**Consultation Response from KC,
Highways Development Management**

2022/92194 Land adj, 21, Thomas Street, Lindley, Huddersfield, HD3 3JJ

Outline application for erection of care home (Use Class C2) of up to 60 beds with associated access

Date Responded: 28-11-2022

Visibility at Site Access (Ref. 152986-001 Rev A)

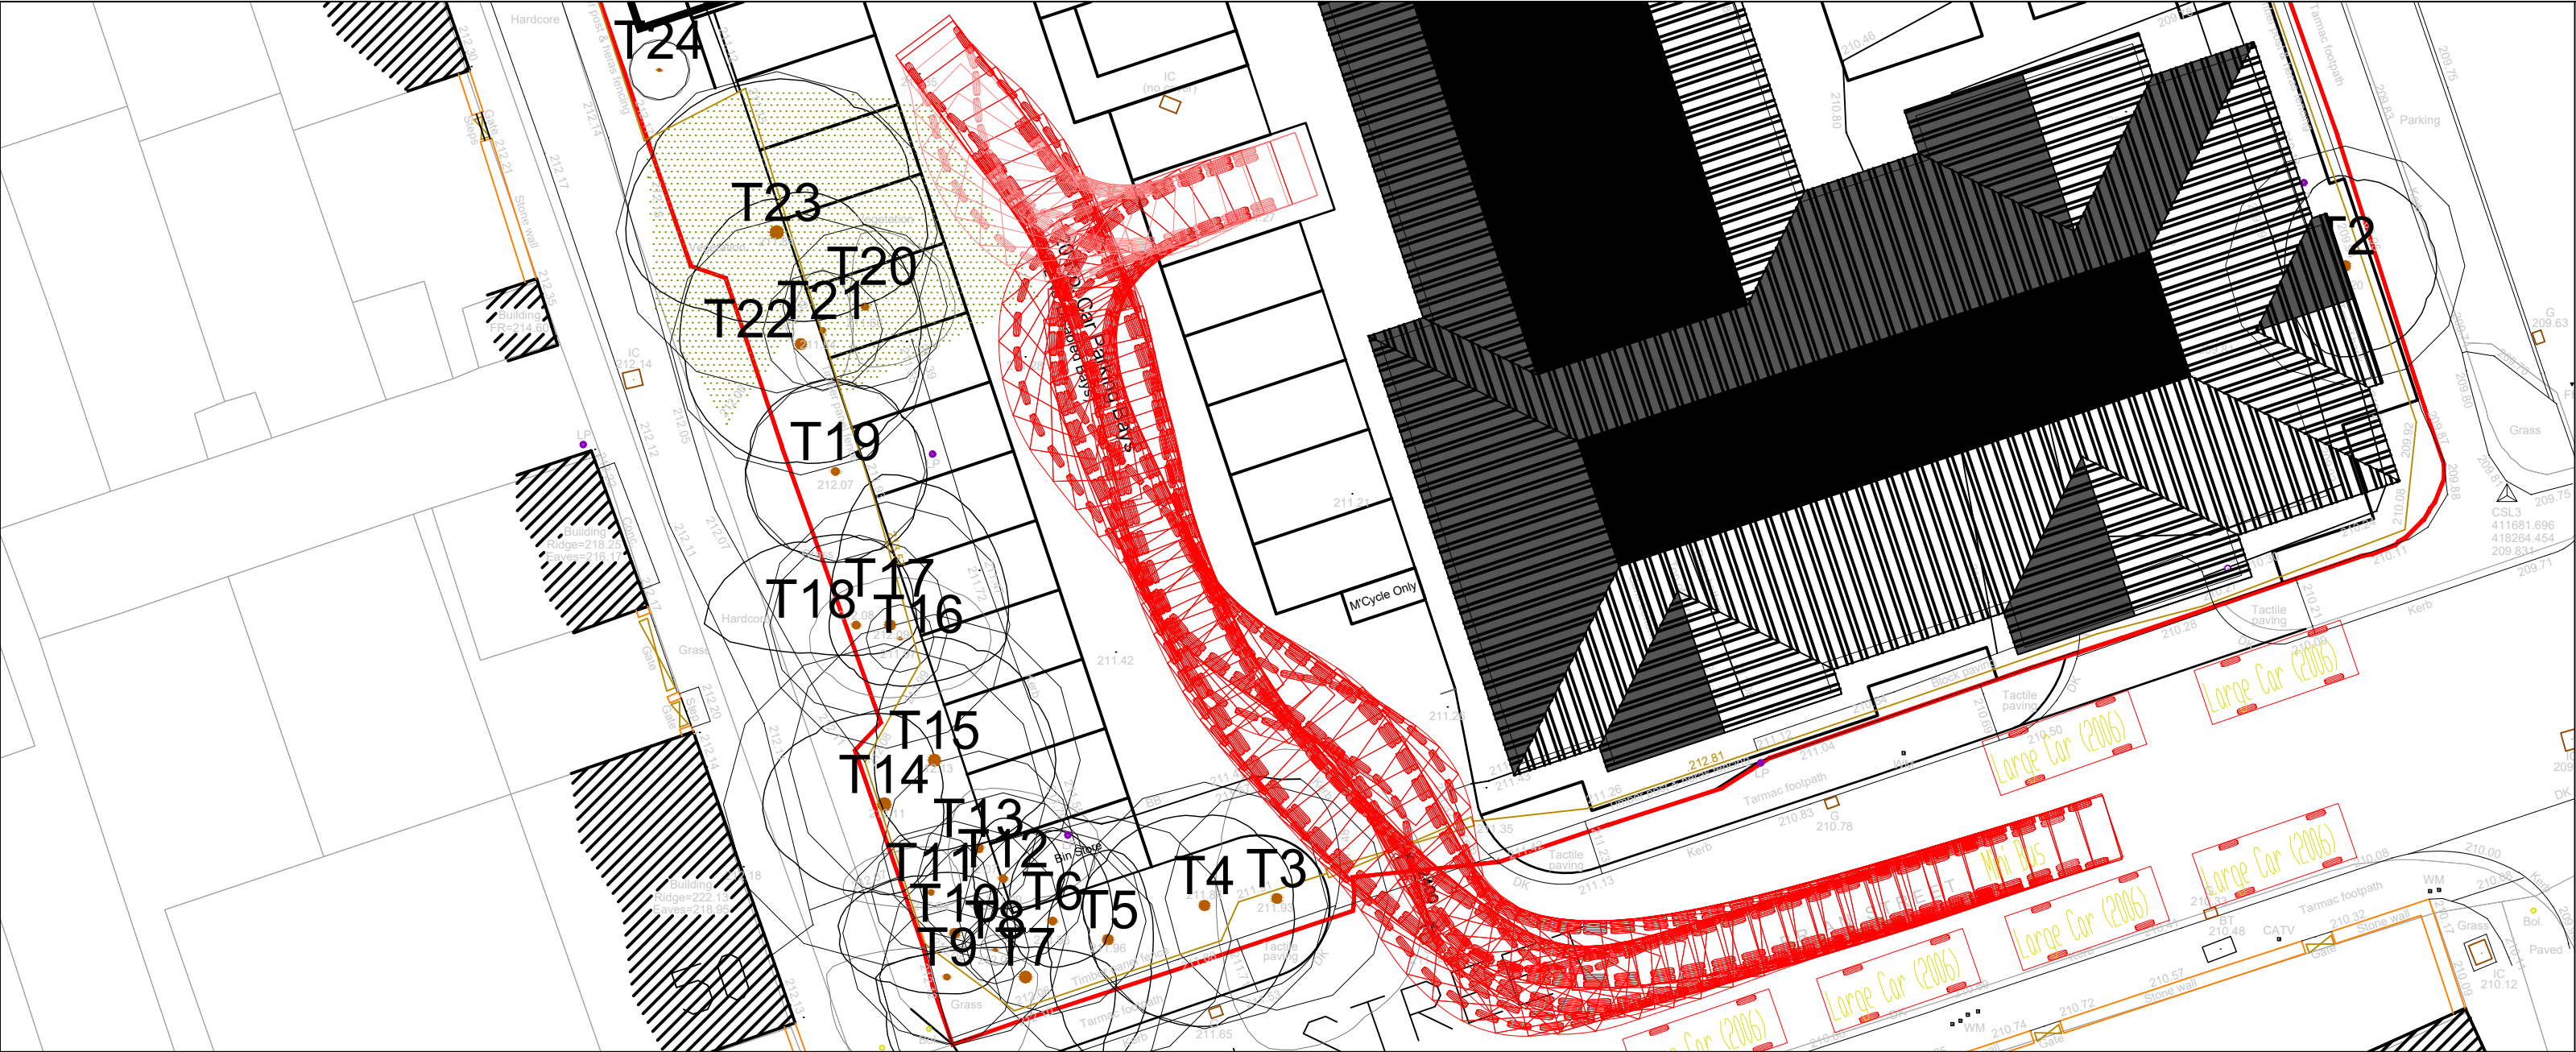
The access visibility is shown with 43m in both directions on Brian Street measured from a minor road distance of 2.4m. The visibility is appropriate for the speed limit on Brian Street.

1, Parking is in high demand in this area. Visibility from that access will be reduced as parking will take place up to the entrance point.

2, Waiting restrictions should be shown to be provided to either side of the junction to assist visibility on to Brian Street.
